Planning Application Decision Notice

REFUSAL OF PERMISSION FOR DEVELOPMENT

Application Number: 2024/62/90389/W

**ERECTION OF STAIRCASE TO FRONT ELEVATION WITH REPLACEMENT
PORCH ROOF AND ALTERATIONS (RETROSPECTIVE)**

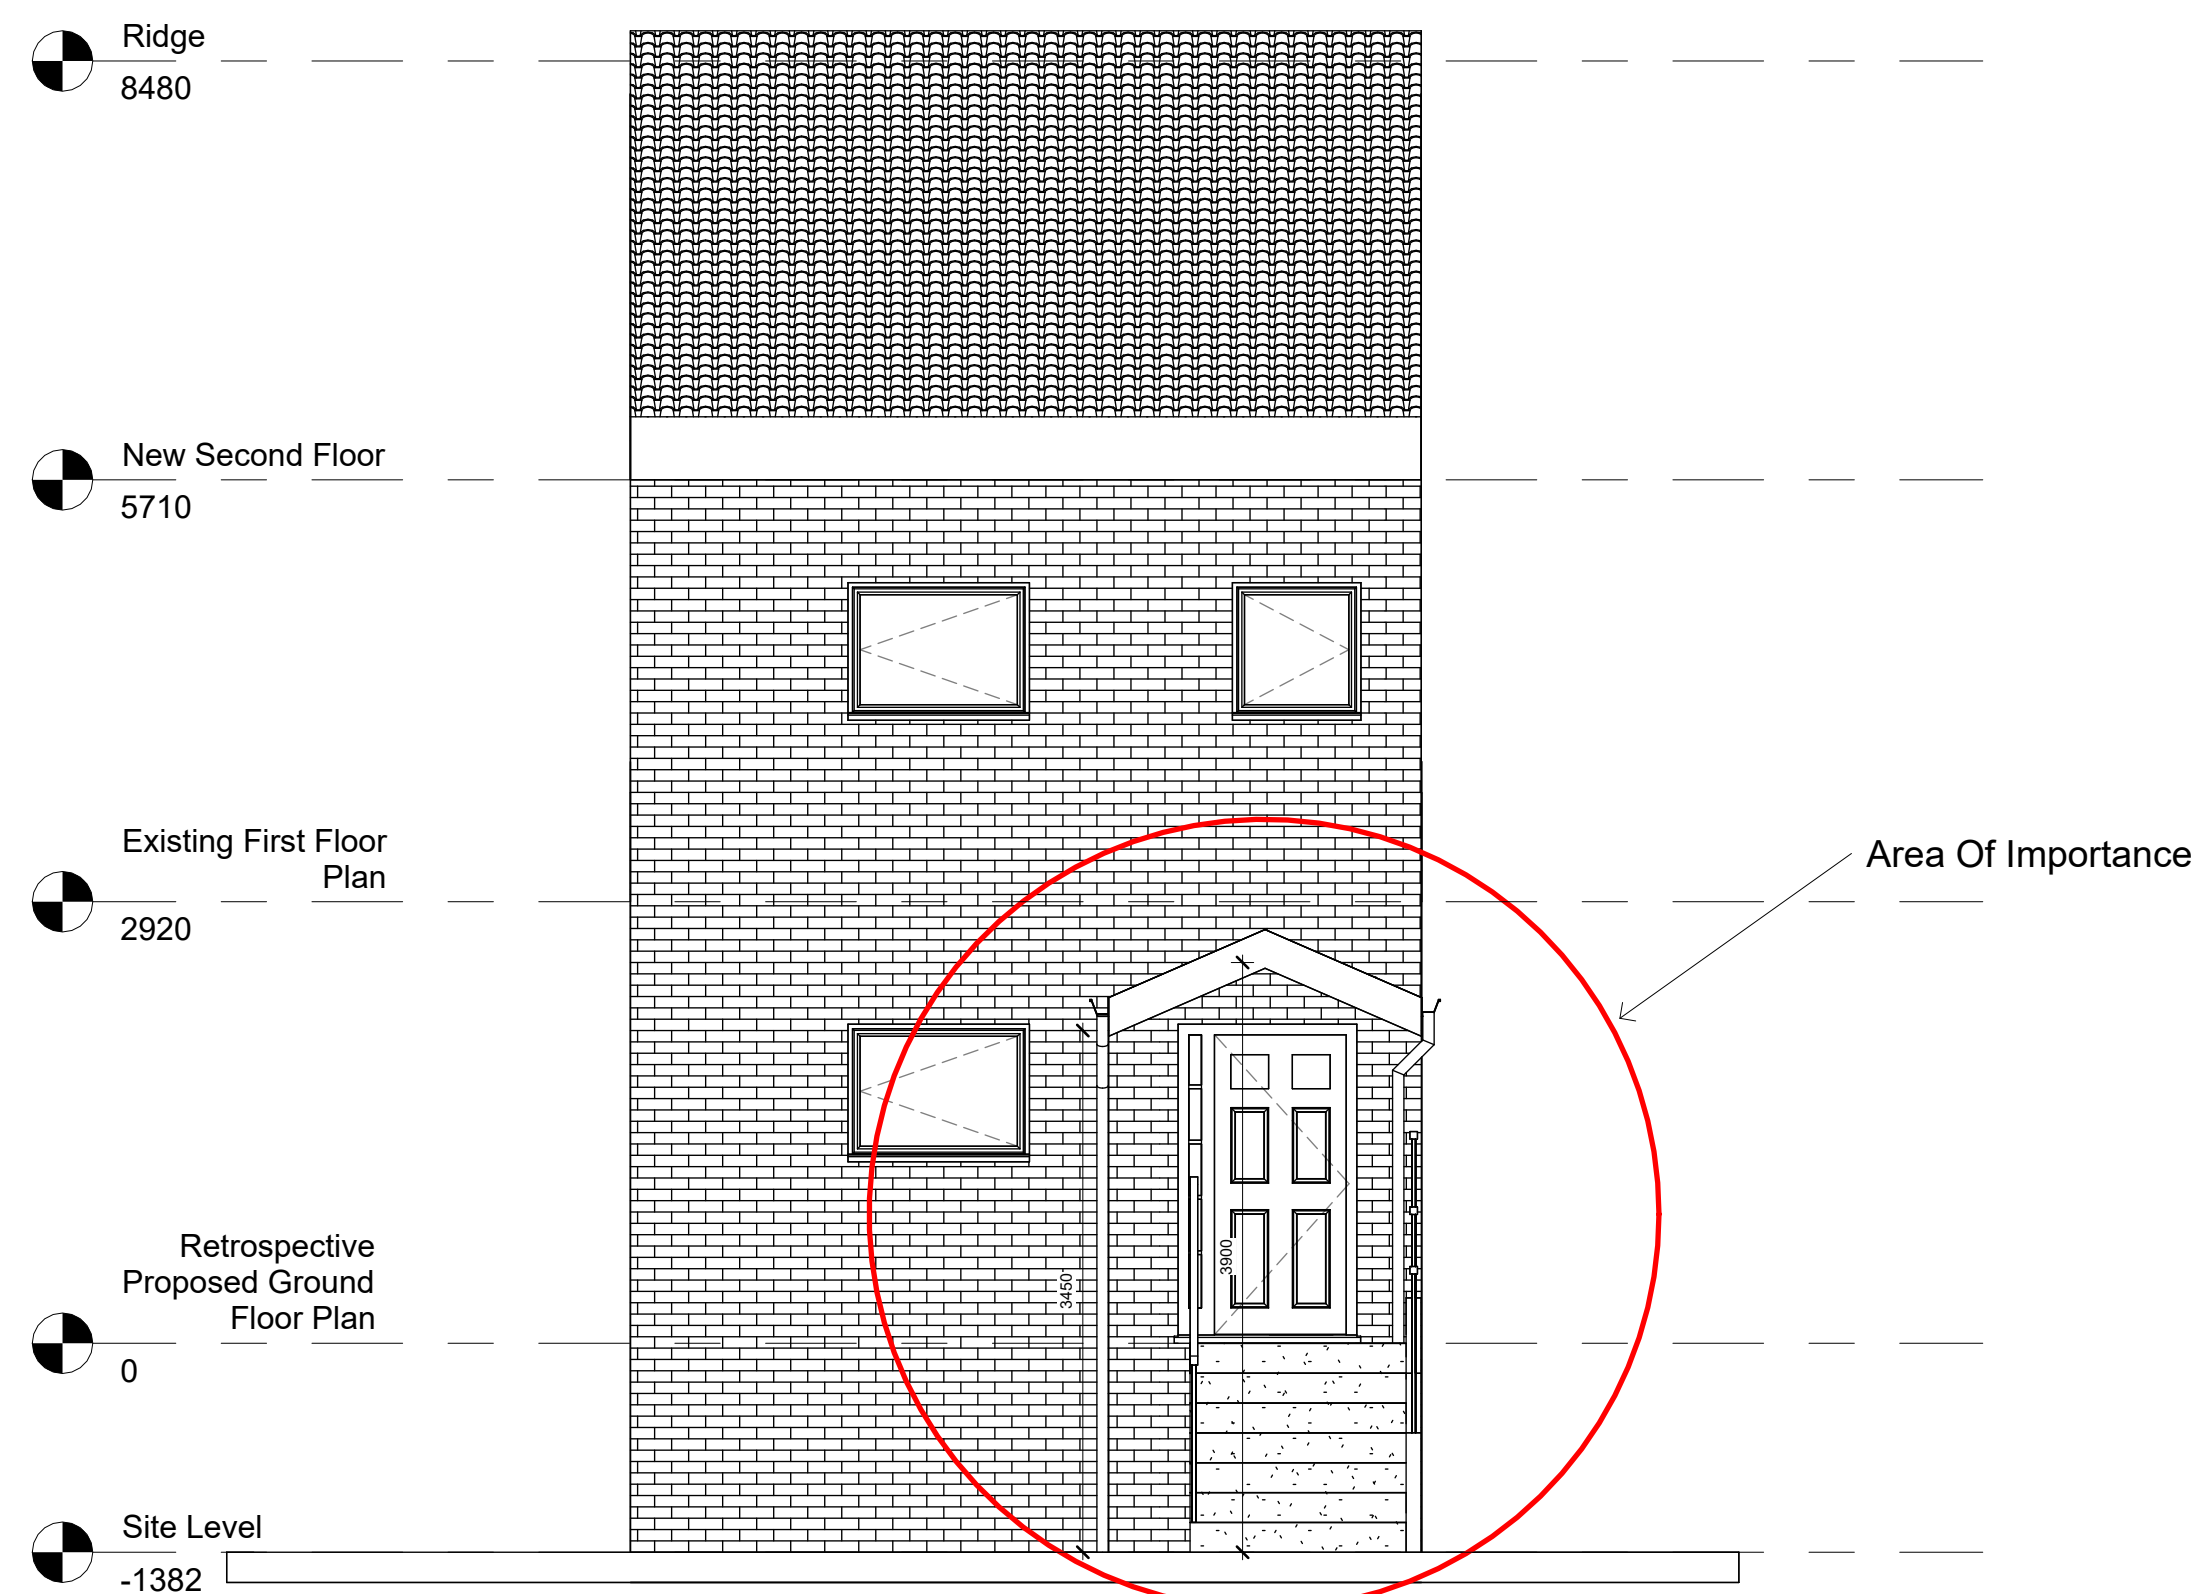
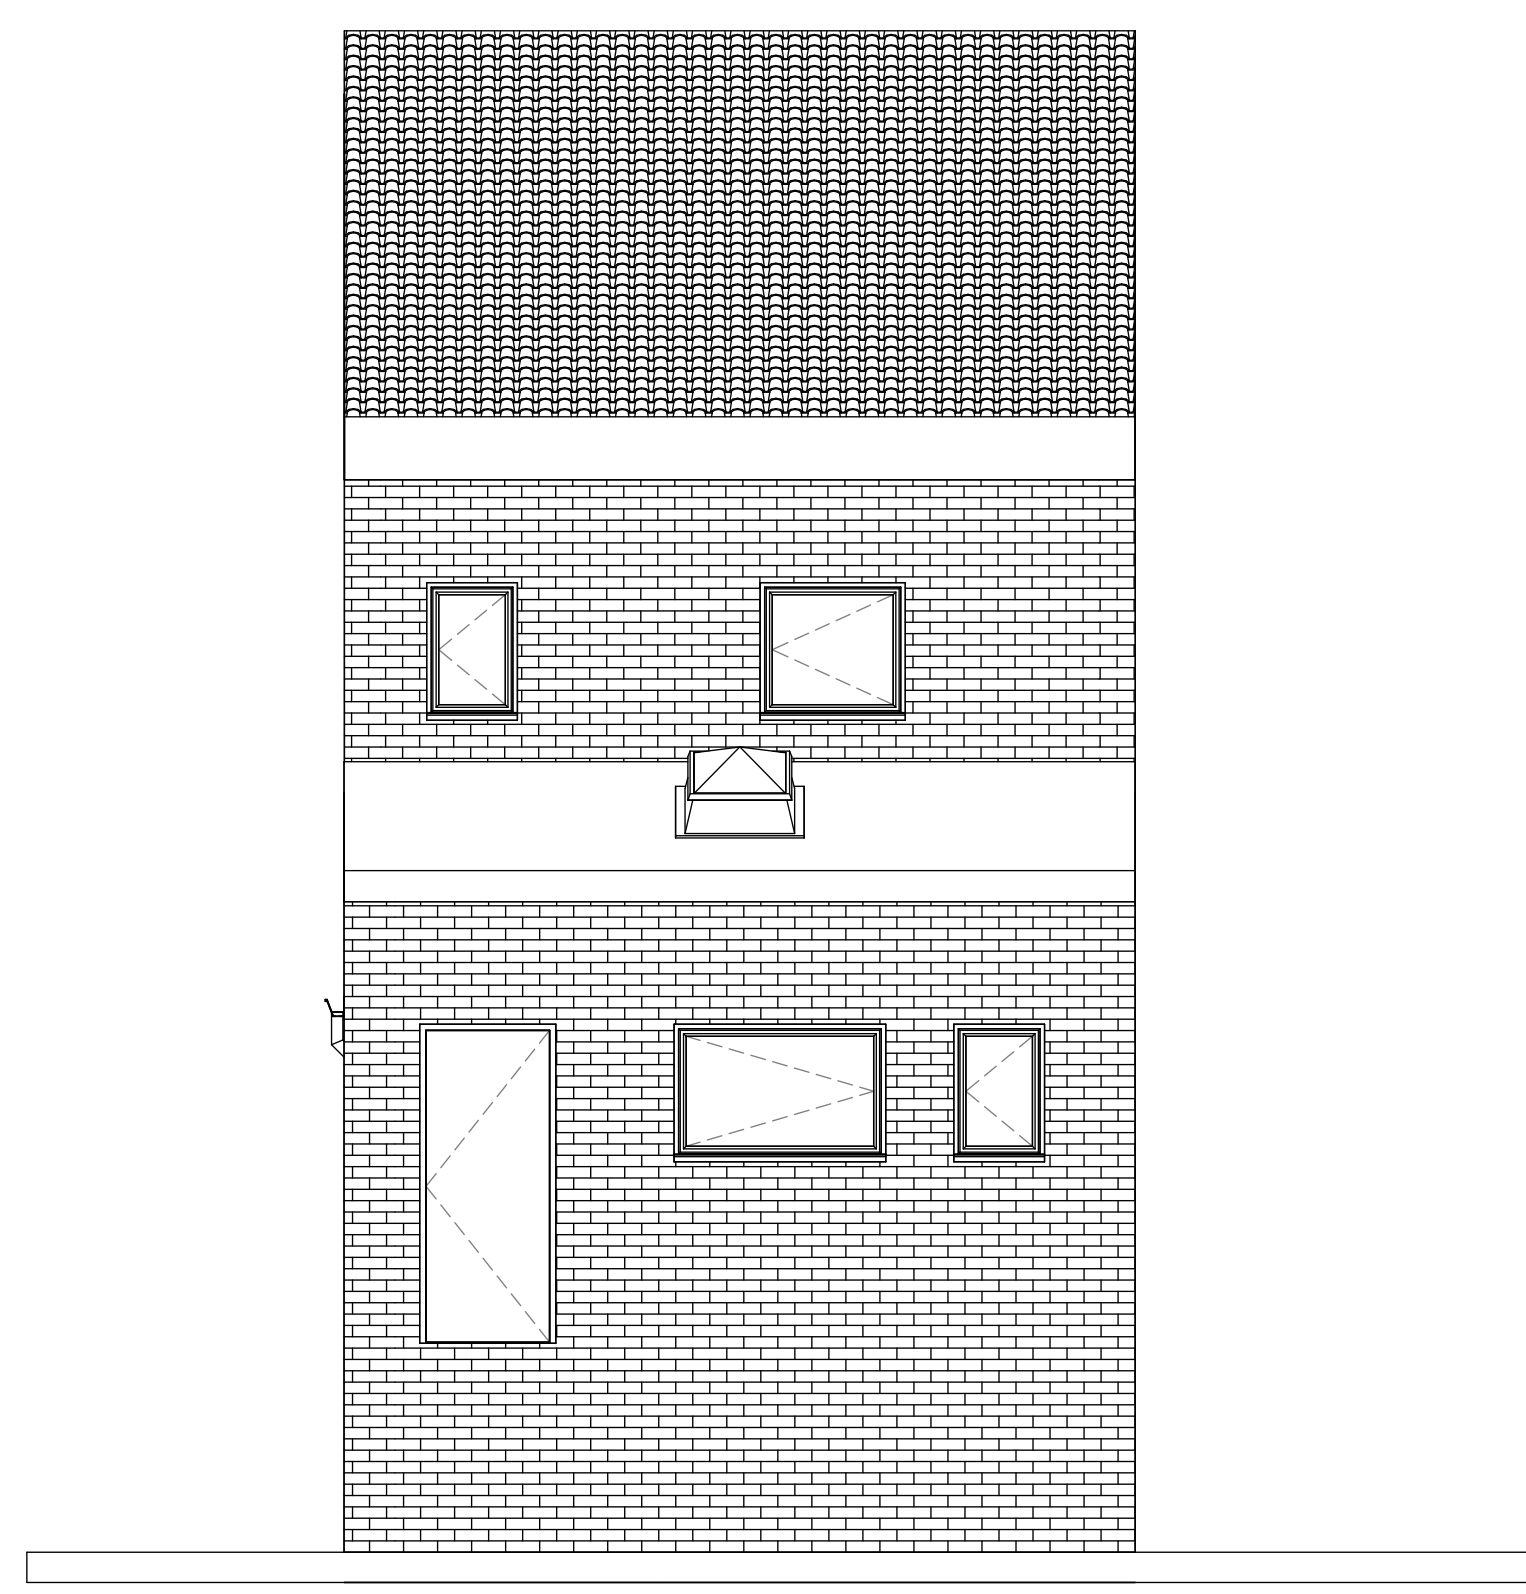
1. The proposed development, due to the prominence and depth of the staircase, in conjunction with the pitched roof of the porch and associated works in totality would detract from the visual amenity of the area and form an overly prominent and incongruous feature which has an adverse visual impact, and which fails to harmonise with the host building and wider terraced row. This would not comply with Policy LP 24 (a and c) of the Kirklees Local Plan, Key Design Principles 1 and 2 of the House Extensions and Alterations Supplementary Planning Document and advice within Chapter 12 of the National Planning Policy Framework.
